Our Case Number: ACP-322958-25

Re: Athlone link road phase 2. Proposed link road, joining the Crescent Junction (R915) to Southern Station Road Junction
Athlone, County Westmeath

**Re: Athlone Link Road Phase 2 and Extension to Bus Eireann Depot
An Comisiún Pleanála Reference No. ACP-322958-25**

Proposed Athlone Link Road Phase 2 and Proposed Reconfiguration and Extension of Athlone Bus Eireann Depot Yard

Figure 1: OPW Floodmaps Extract

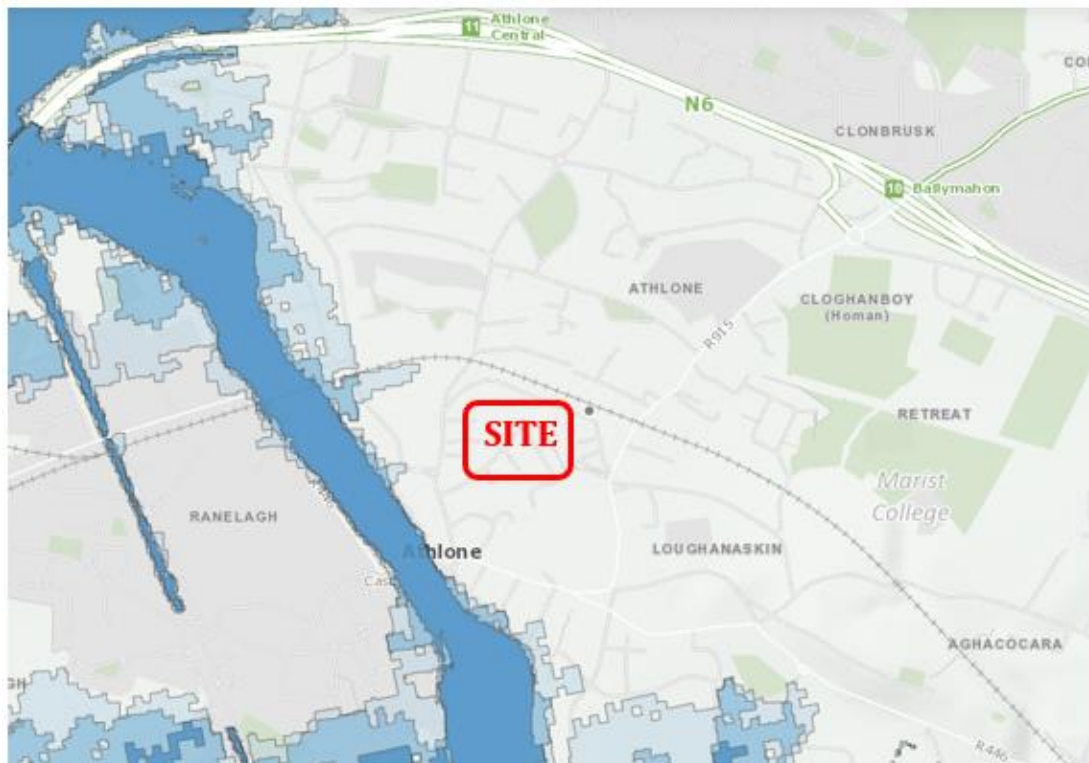
The Drainage Design Report, Section 2.2, Surface Water Drainage Design Options, considers two options, 1. Infiltration to Groundwater, and 2, Discharge to the existing storm water drain to the west. The report recommends Option 2 and accordingly recommends replicating existing run-off rates by providing on-site attenuation together with a restrictor to ensure run-off is controlled to pre-development or local authority dictated run-off rates. The report recommends that drainage attenuation system should be sized to accommodate all storm durations and intensities up to the 1:30 year storm without surface water leaving the site. Drainage Drawing No.120278-501 submitted with the application indicates attenuation measures including hydro-brakes at two locations and an attenuation tank on the bus depot extension site. Section 2.3 of the Report

states that discharge from the development site will be controlled by a hydro-brake to limit flows equivalent to greenfield run-off and that lagoons will be sized to accommodate surface water run-off arising from the new hard paved surface areas for up to and including the 1:30 year rainfall event plus an allowance for climate change (20%). It states that exceptional events in excess of the 30-year storm may overtop the discharge control (hydro-brake) and result in short term uncontrolled flows towards the culvert. The report states that this will not impact the surrounding residential dwellings. However, the surrounding residential dwellings, including St. Francis Terrance and The Manse, are on the upstream side of the catchment in relation to the proposed development site. The concern is the downstream part of the catchment from the point at which the surface water discharges from the site at the culvert under Southern Station Road to the final discharge at the outfall point to the River Shannon c. 350m west of the site. In its Flood Risk Management (FRM) General Guidance, the OPW states that reference should be made to the Guidelines on the Planning System and Flood Risk Management, (DHPLG/OPW, Nov. 2009), issued under Section 28 of the Planning Acts, to ensure that the key principles of flood risk management and sustainable planning are adopted. The guidelines set out a three Stage Flood Risk Assessment process for the Planning Authorities to identify whether a flood risk may exist, and the degree to which it is an issue, and what assessment to a scale proportionate to the risk should be carried out. In an overview of this three-stage process, the OPW describes stage 1 as: 'Stage 1 Flood risk identification – To identify whether there may be any flooding or surface water management issues related to a plan area or proposed development site that may warrant further investigation'.

However, surface water drainage issues in the part of the catchment downstream of the subject site do not appear to have been considered.

Storm Drainage Network Drawing

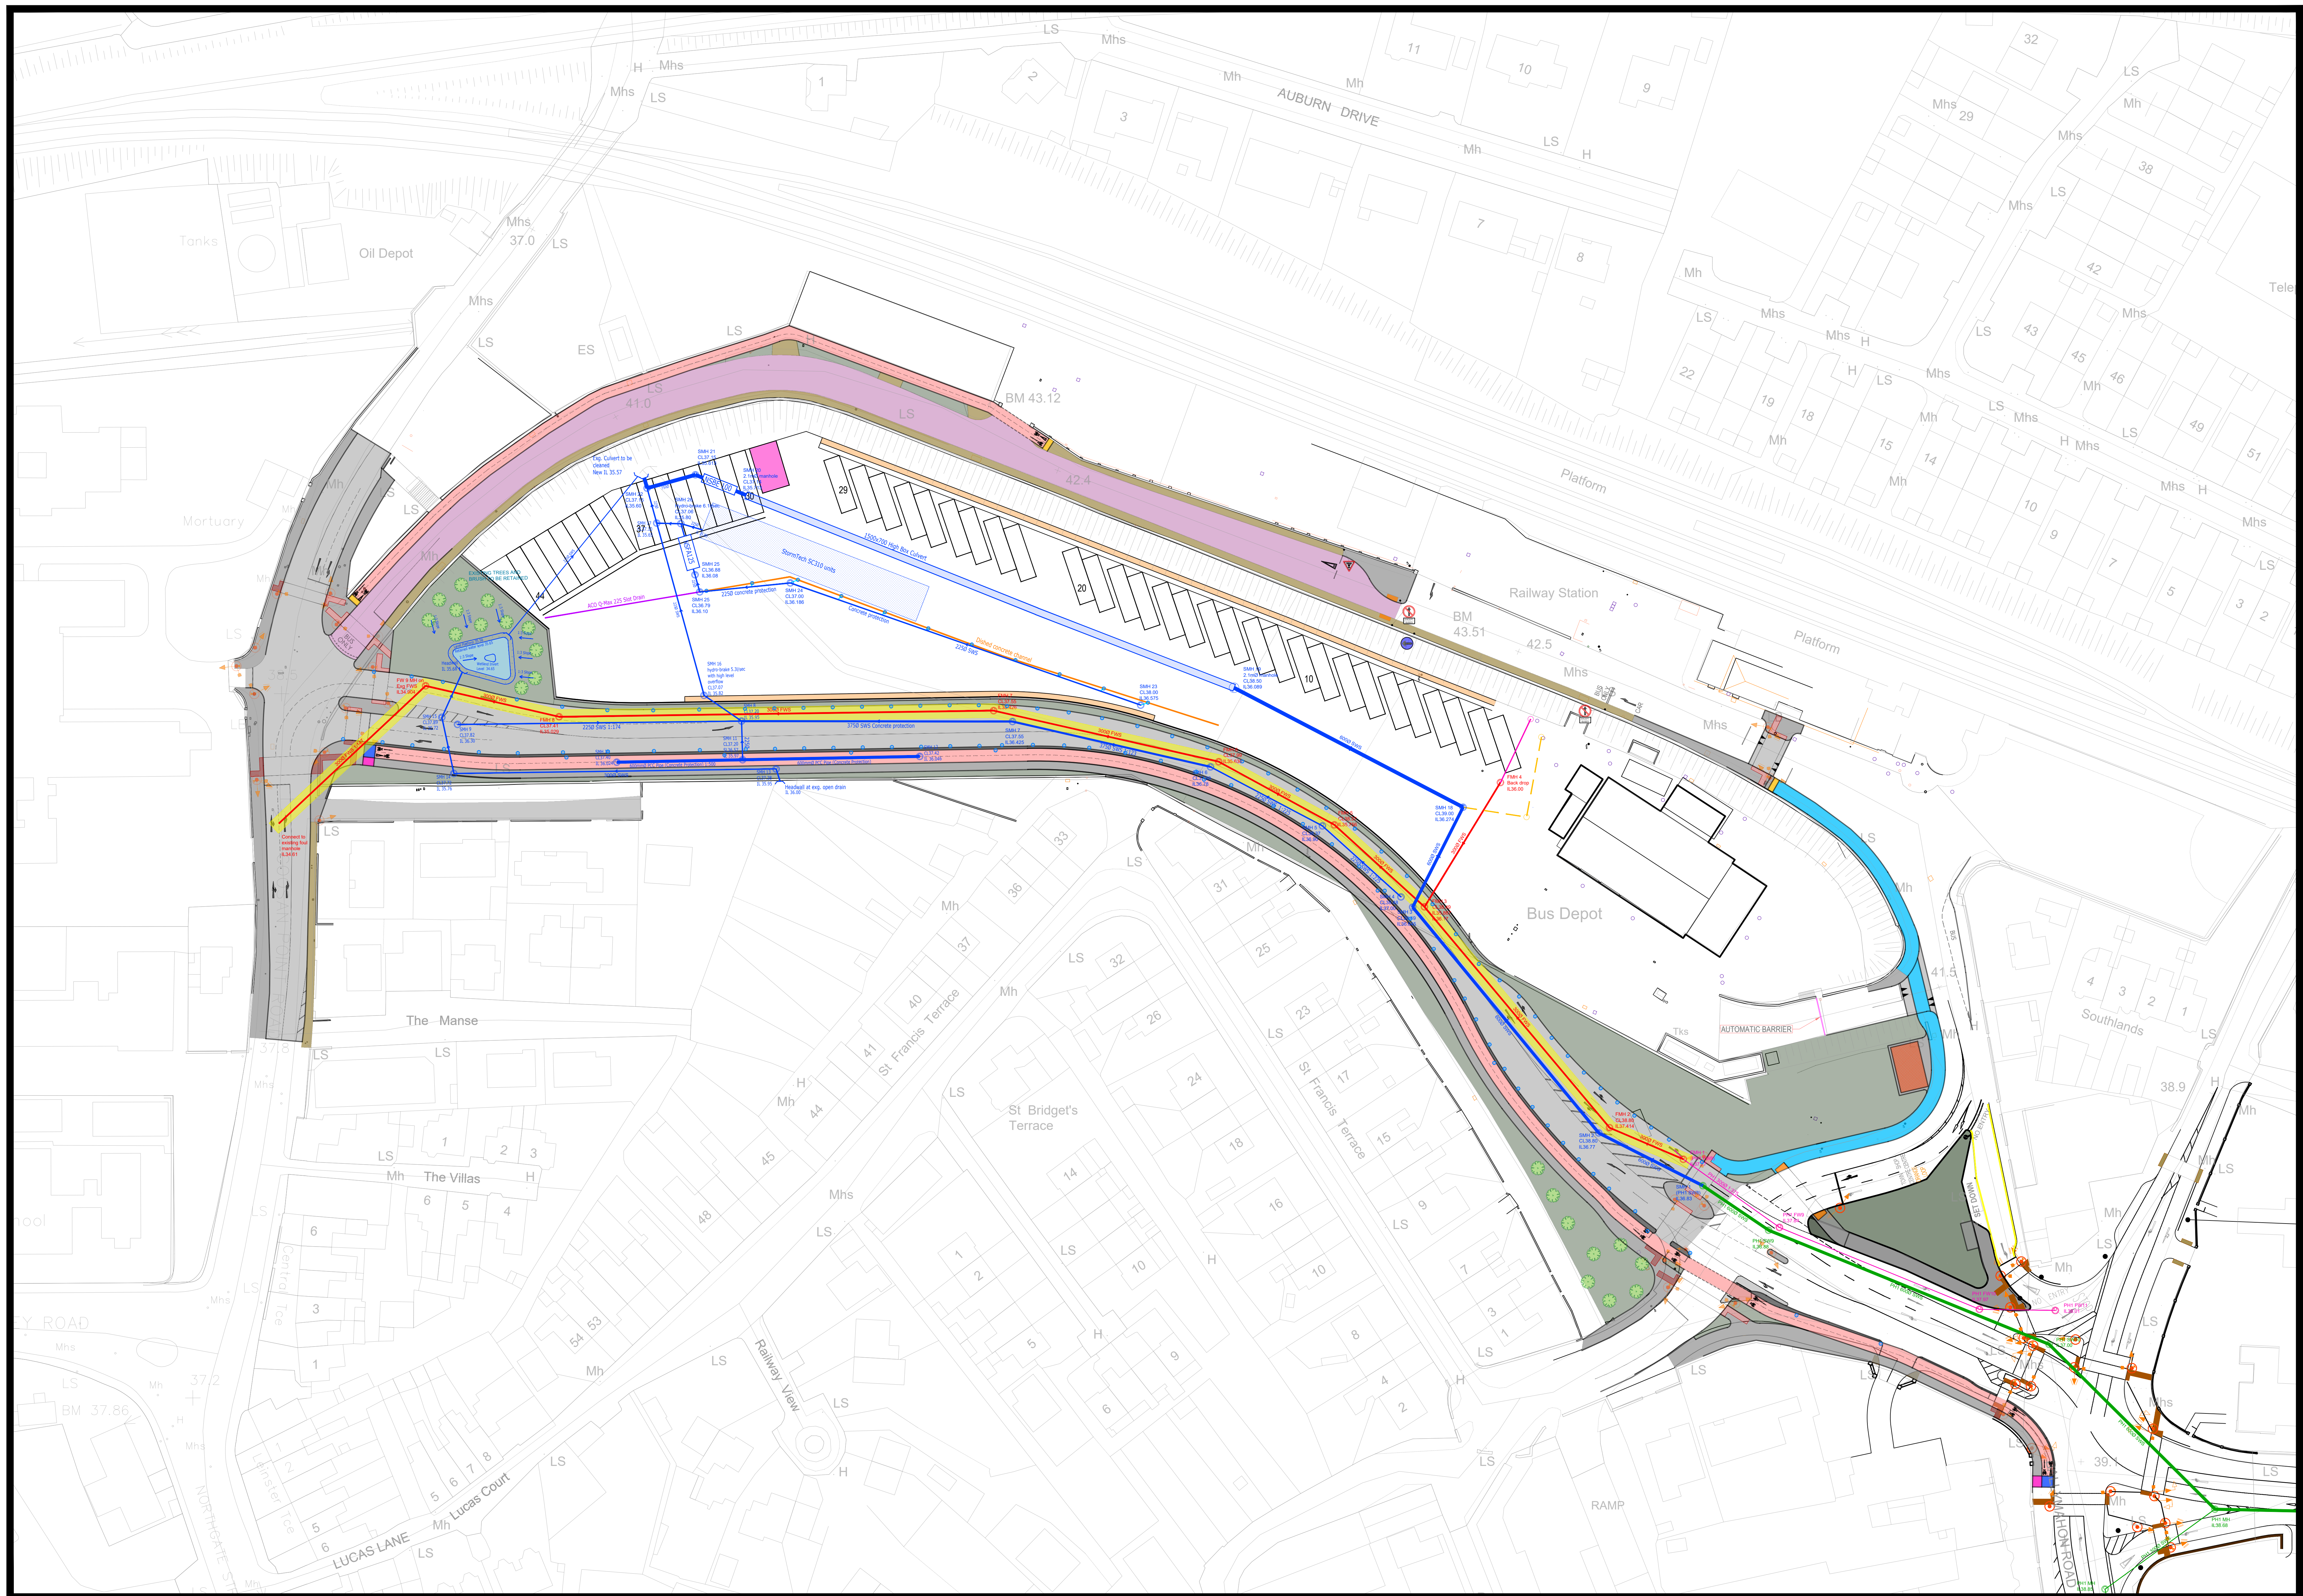
The link Road, the bus depot extension combined with the existing bus depot at the eastern end of the site will result in a substantial increase in storm water runoff from the area to the stream flowing through the centre of the site. The design proposals include a number of retention measures.

Therefore, in the event of extreme rainfall events of durations and intensities exceeding the 1:30 year flood event, the lands and properties downstream of the discharge point from the site will be at risk of flooding. If such extreme rainfall events coincide with the closure of the non-return valve at the stream outfall point and sustained high water at levels on the River Shannon prevent the opening of the non-return valve, Hanleys property and surrounding properties to the east of Hanleys will be at risk of immediate and extremely damaging local flooding and, from a commercial perspective, potentially catastrophic flooding. This scenario cannot be discounted in the light of the unpredictability of severe weather events associated with climate change.

It is likely to be inevitable that the extensive impermeable paving proposed for the Link Road and Bus Depot Extension Site will have a significant impact on the volumes of surface water run-off from this relatively small and confined catchment area. The attenuation measures proposed, while practical in most development scenarios, have stated limitations when considered in the context of the downstream catchment area. It is recommended that additional preventative and protection measures be considered. A review of the storm return period and an increase in attenuation capacity in addition to a permanent automatic pump installation at the outfall location at the River Shannon, are measures that should be considered.
